KIRKLEES METROPOLITAN COUNCIL INVESTMENT & REGENERATION SERVICE

DELEGATED DECISION TO DETERMINE APPLICATIONS FOR LISTED BUILDING CONSENT

Reference No:	2024/65/92106/E
Site Address:	Wesley House, Huddersfield Road, Birstall, Batley, WF17 9AZ
Description:	Listed Building Consent for alterations to convert former offices to 21 apartments (within a Conservation Area)
Recommending Officer:	Nina Sayers

Officer Report

Proposed Third Floor Plan
1:100 @ A1

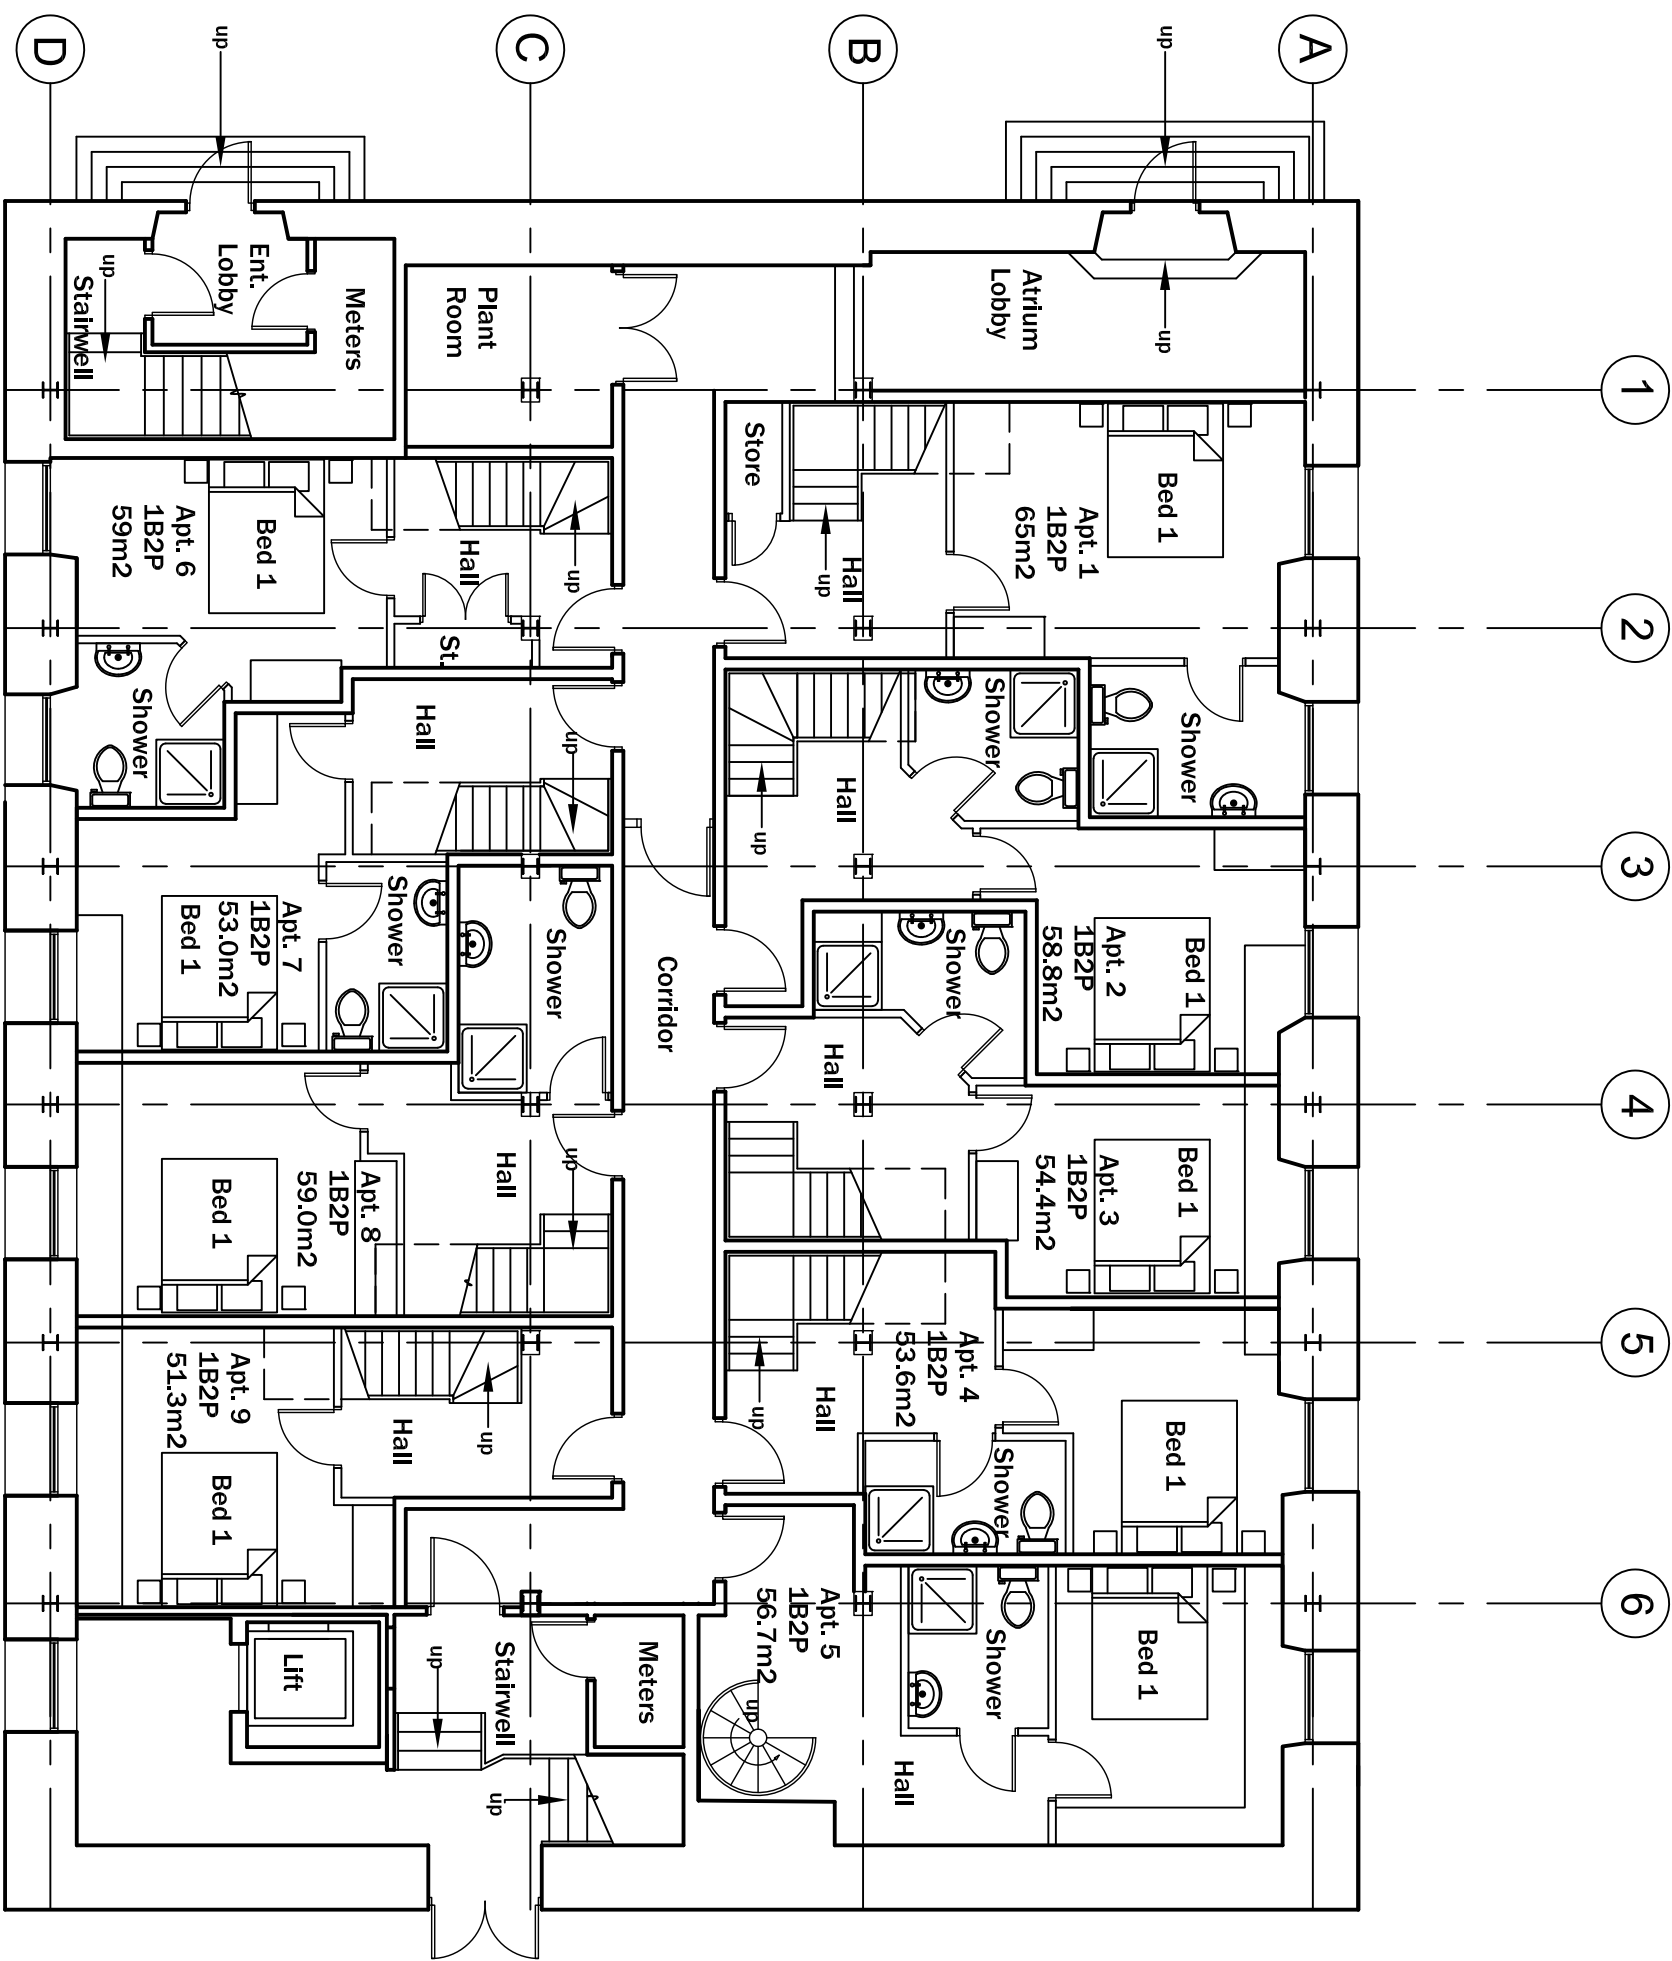
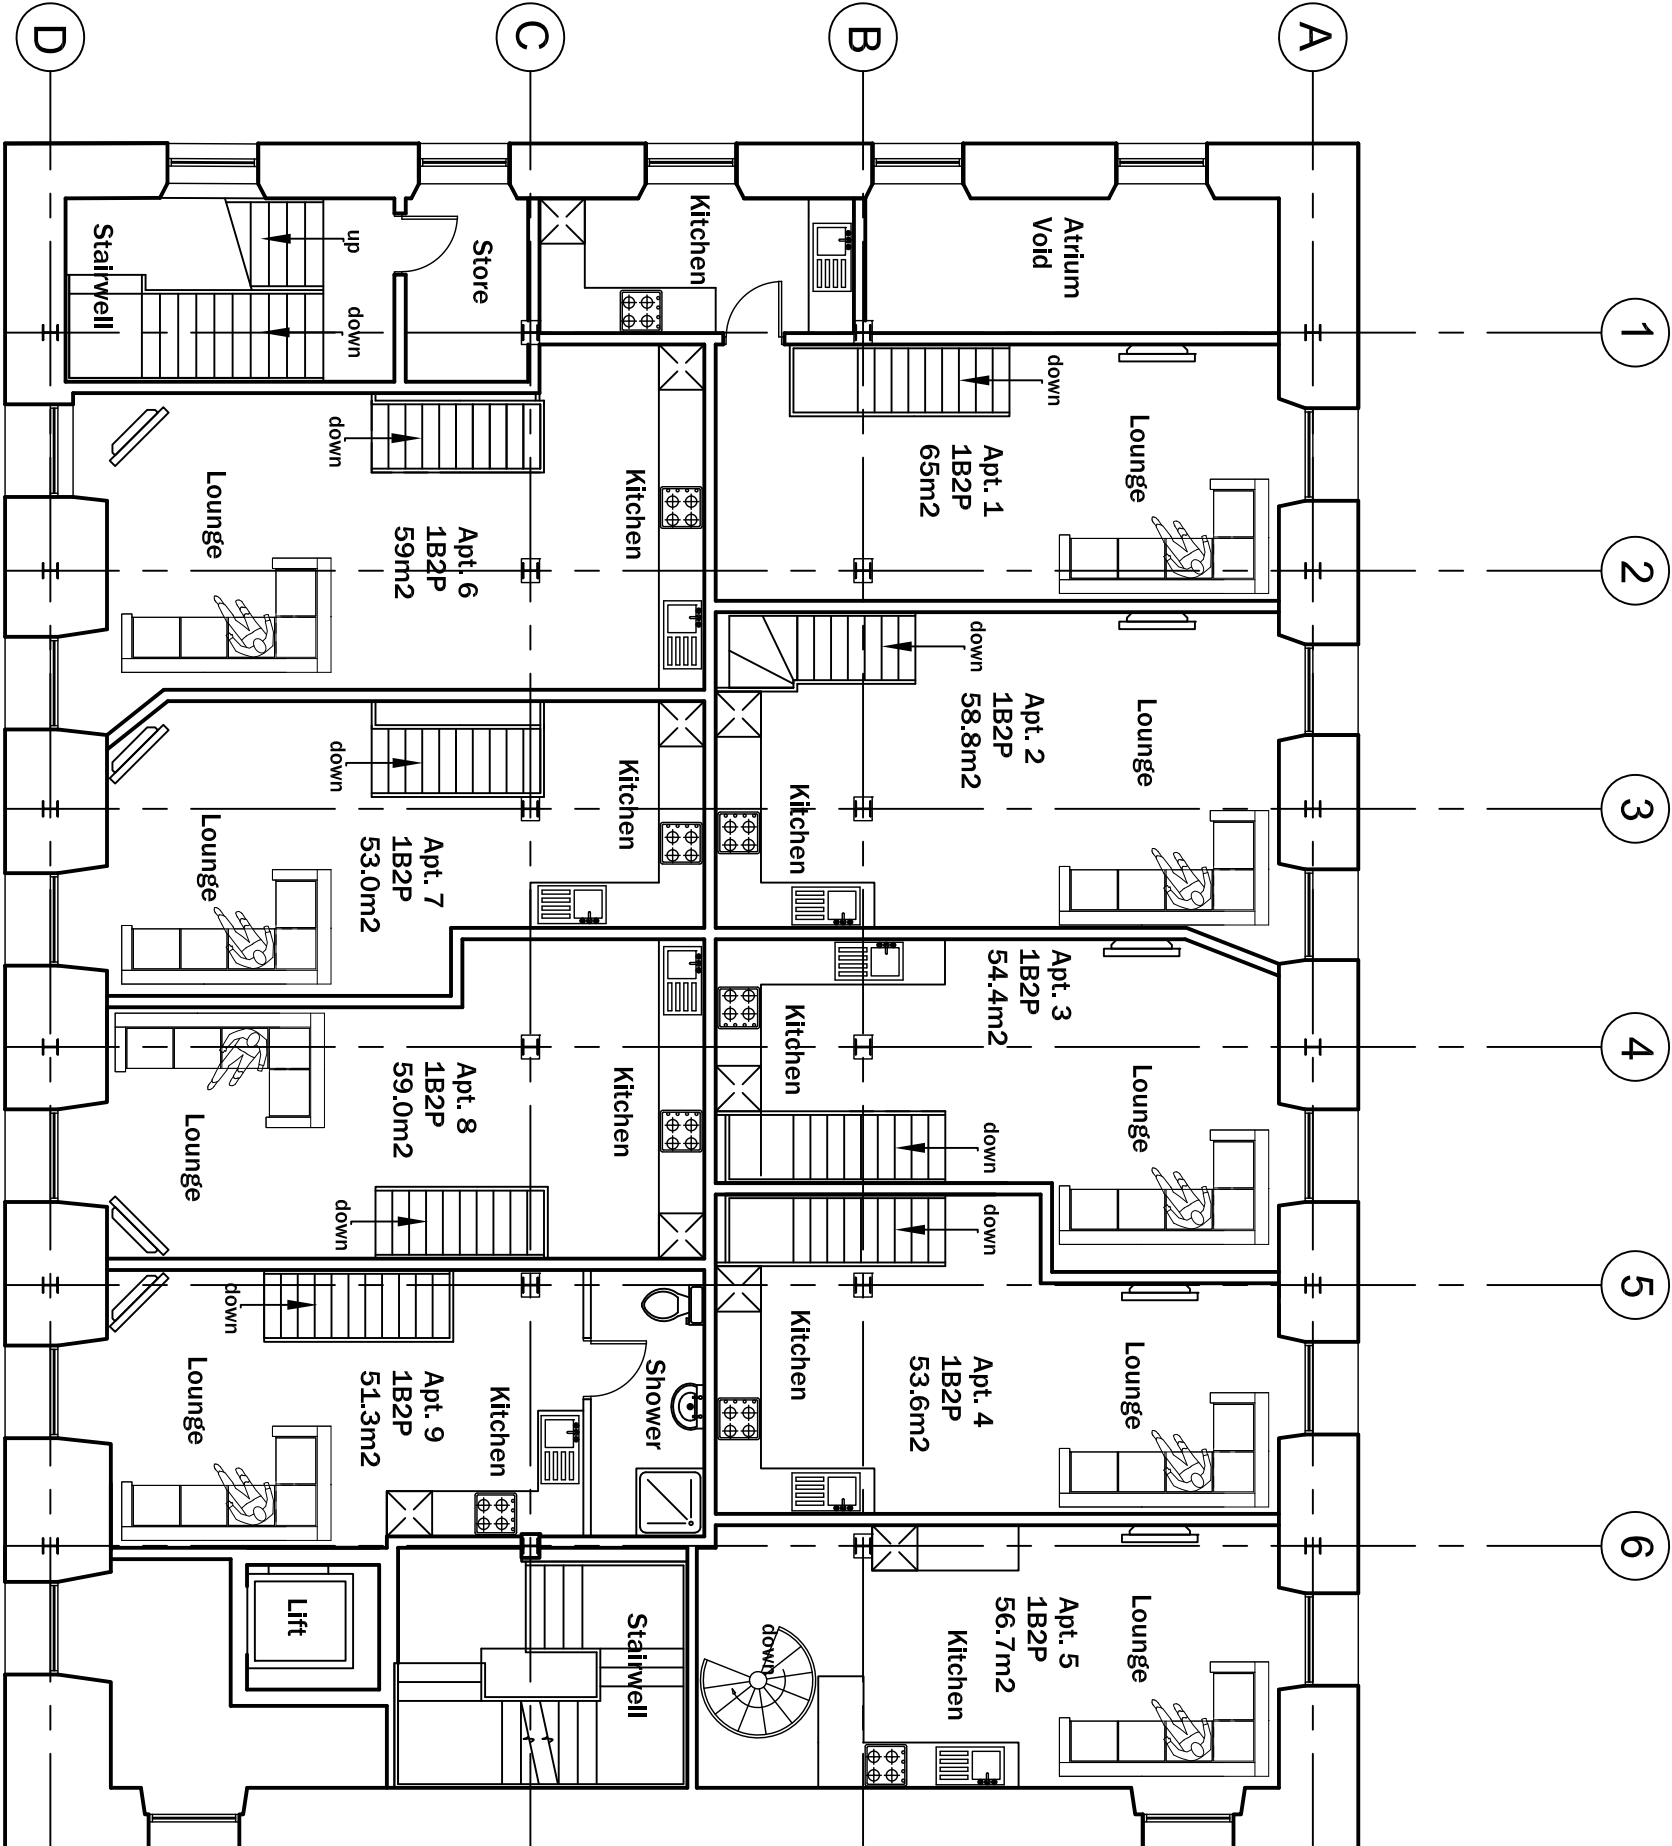
Officers had concerns regarding the ground and second floor living accommodation which is only served by small openings. The applicant

discussed the idea of adding additional openings however, in the interest of preserving the listing building and not causing harm to visual amenity, officers outlined they would not support additional openings. Instead, a revised internal layout was provided which proposed the kitchen area to the lower levels and all other living accommodation to the upper levels which have larger openings.
